# PLANNING AMENDMENT

H11/0235/01

PLOT ADJACENT TO 15 SWARCOAT LANE, LONG SUTTON, SPALDING

Amendment: Design alterations  
Dwg. nos. 0021/01/01 & 0021/55/01

EXISTING DWELLING.

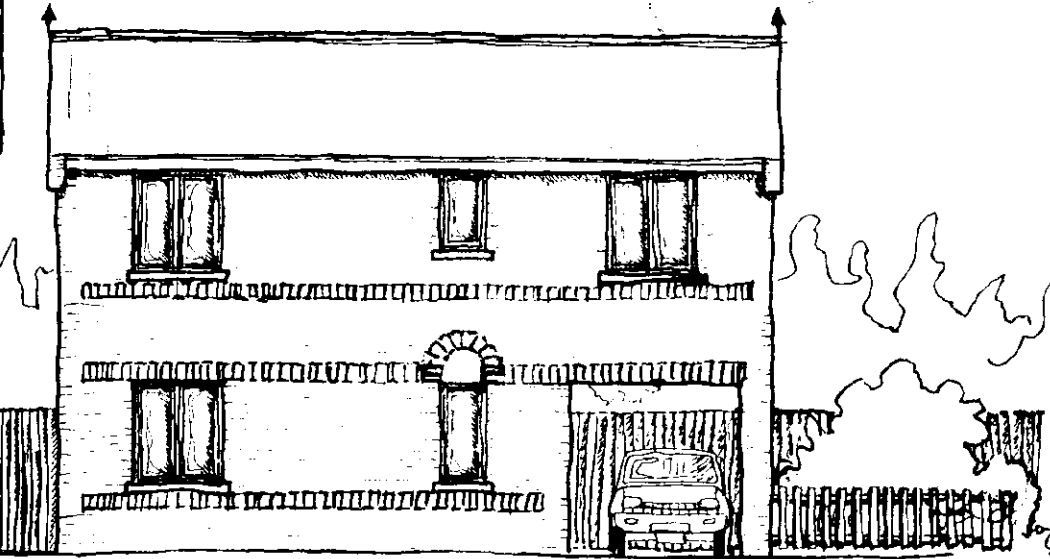
- ARCHED SOLDIER COURSE WITH RENDER INSET OVER WINDOW ON FRONT ELEVATION. TO MATCH EXISTING PROPERTY ADJACENT.  
- STRAIGHT SOLDIER COURSE & ARCHED SOLDIER COURSE WITH WITH RENDER INSET OVER WINDOW TO REAR ELEVATION TO ENHANCE AESTHETICS.  
- DECORATIVE FINIALS ADDED TO MATCH EXISTING BUILDING ADJACENT.  
- LIGHTING TO CAR PORT FOR SECURITY.
